Rezoning Transportation Analysis

Petition Number: 2023-044

From: Jake Carpenter, PE
Jacob.carpenter@charlottenc.gov
980-221-5675

Revision Log:	Date	Description
	07-26-23	First Review (TM)
	8-23-23	Second Review (ME)

RZ-1

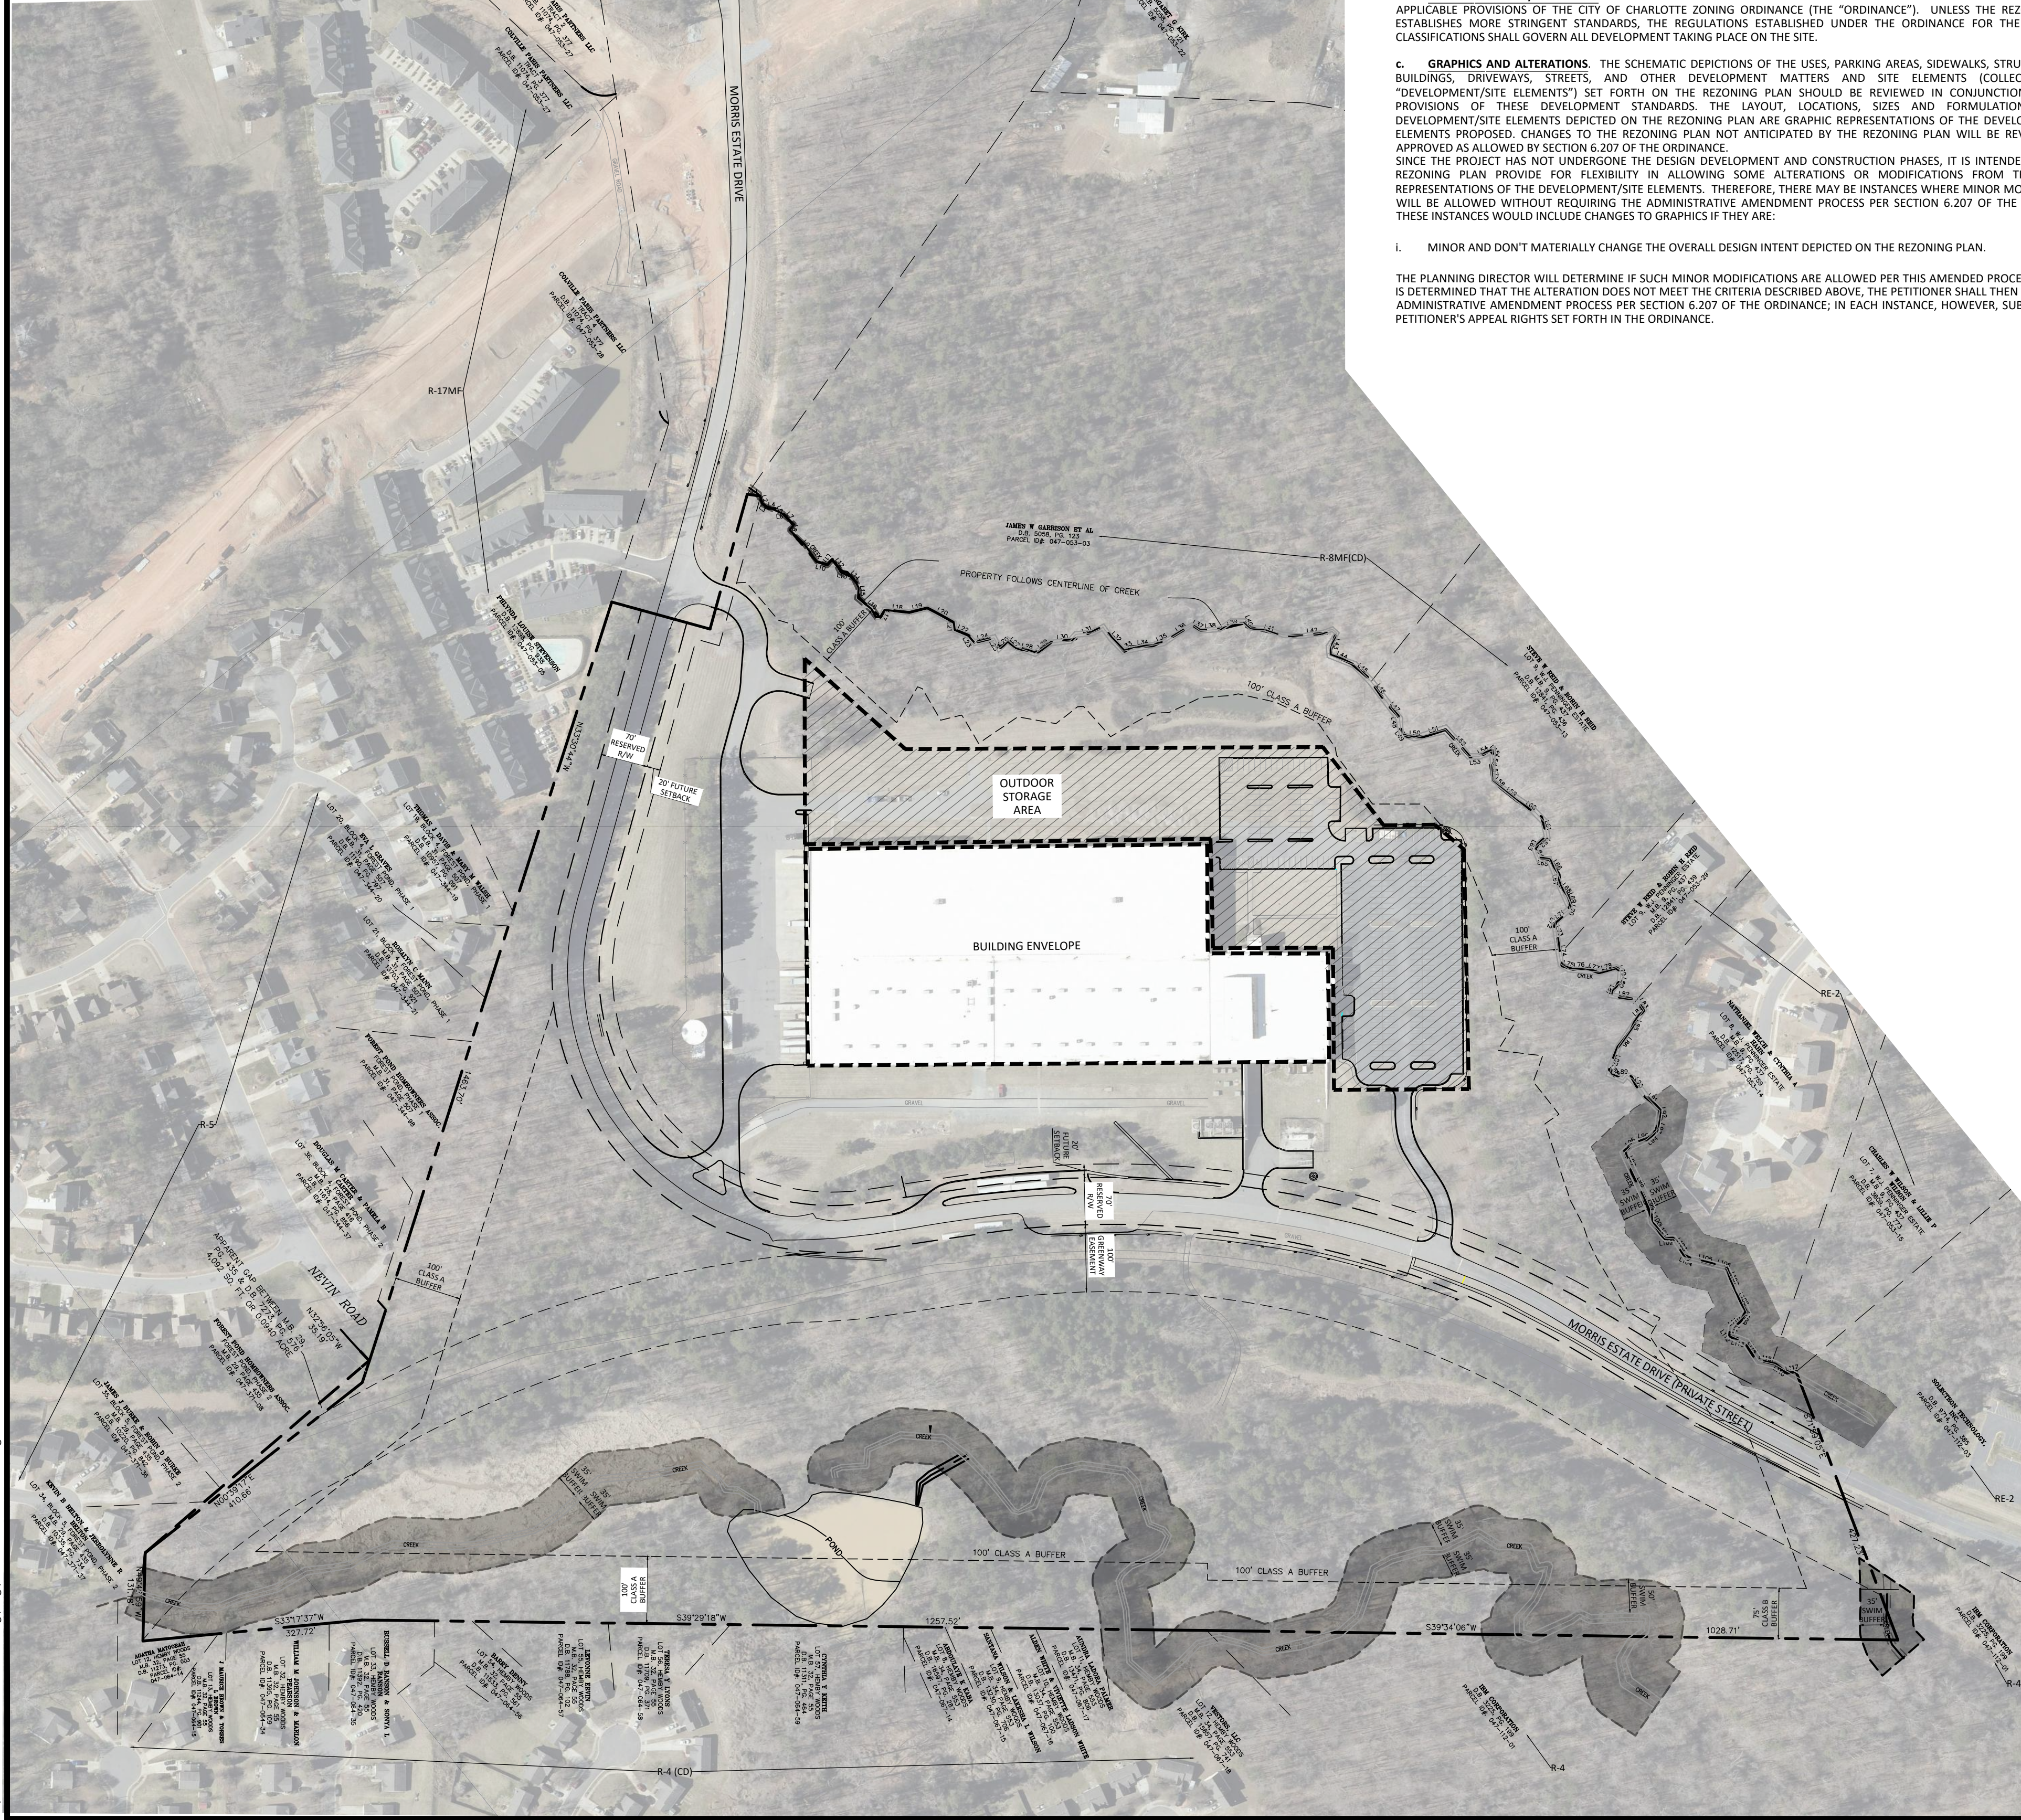
- a. ~~**Morris Estates Drive:** Location of curb and gutter to be moved to 24 feet from roadway centerline to accommodate the Charlotte Streets Map with a roadway typical section of 2+ Avenue with Bike Lanes.~~

3. ~~Revise site plan and conditional note(s) to commit to reserving 80 feet of right-of-way from the road centerline along Morris Estates Drive. The site plan shall label and dimension the right of way from the road centerline.~~
